DRB CASE ACTION LOG (SITE PLAN SUBD)

DRB Application No.: **06DRB-00558 (SPS)**
Project Name **CANYON GROVE SUBDIVISION**
Agent: Isaacson & Arfman PA

FILE: **Project # 1003116**
05EPC-00020 EPC Site Development Plan-
Subdivision
05EPC-00021 EPC Site Development Plan-
Building Permit

DRB CASE NO/PROJECT NO: 1003116

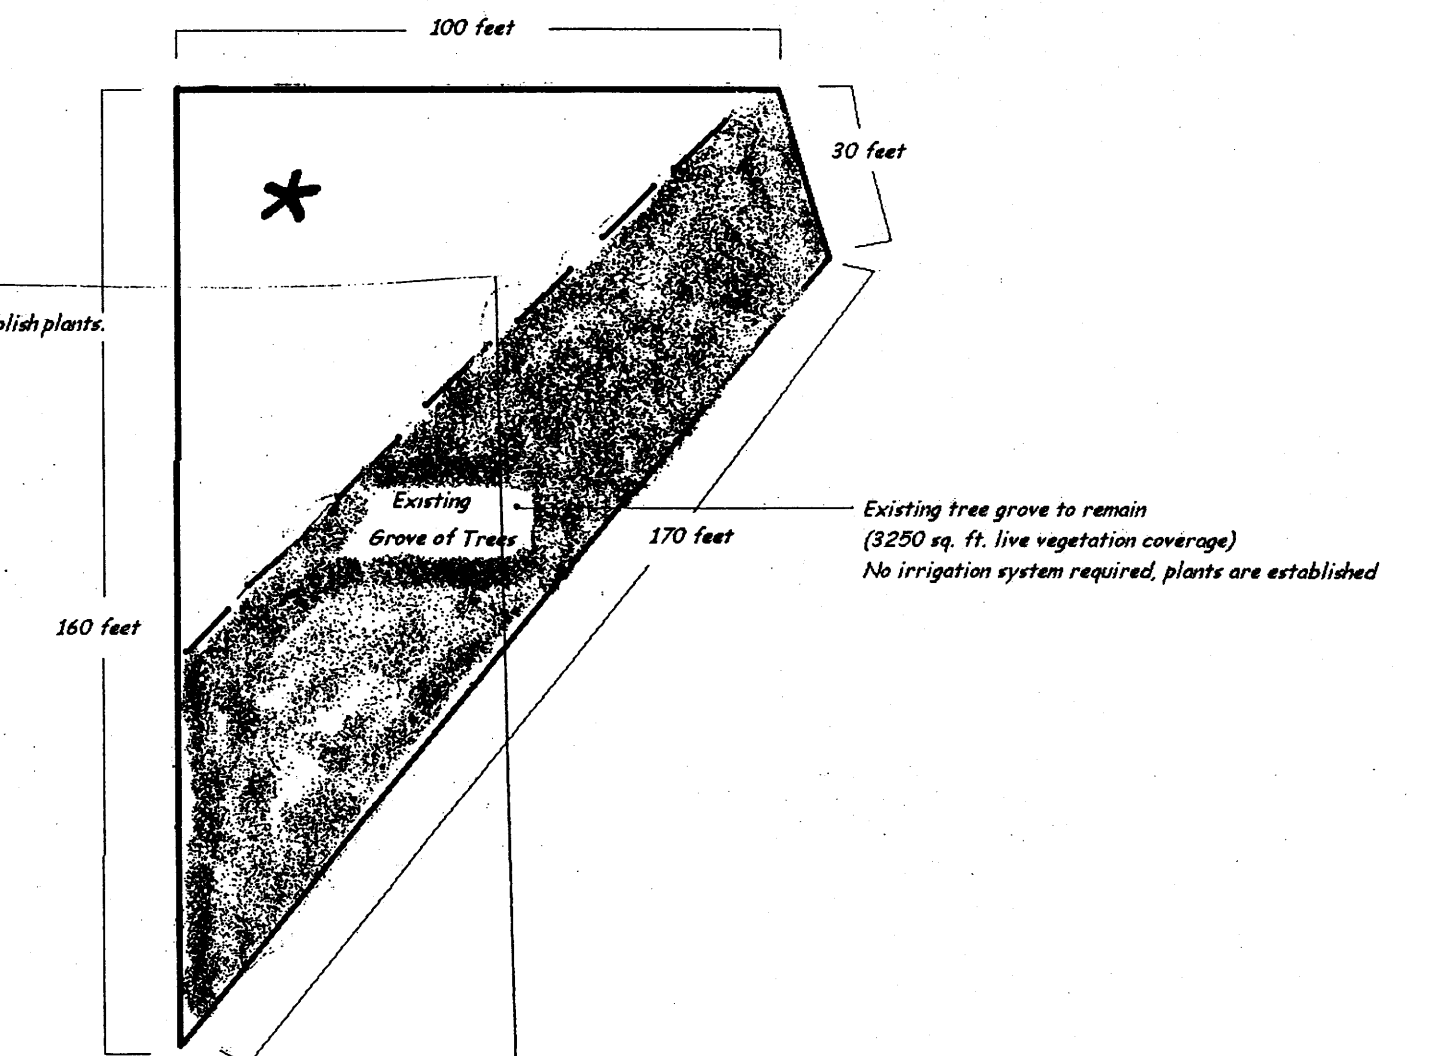
PLANNING (Last to sign): 3 copies
Case planners initials: David Stillworth
Revised Landscape Plan - identify shrubs, 3" gravel
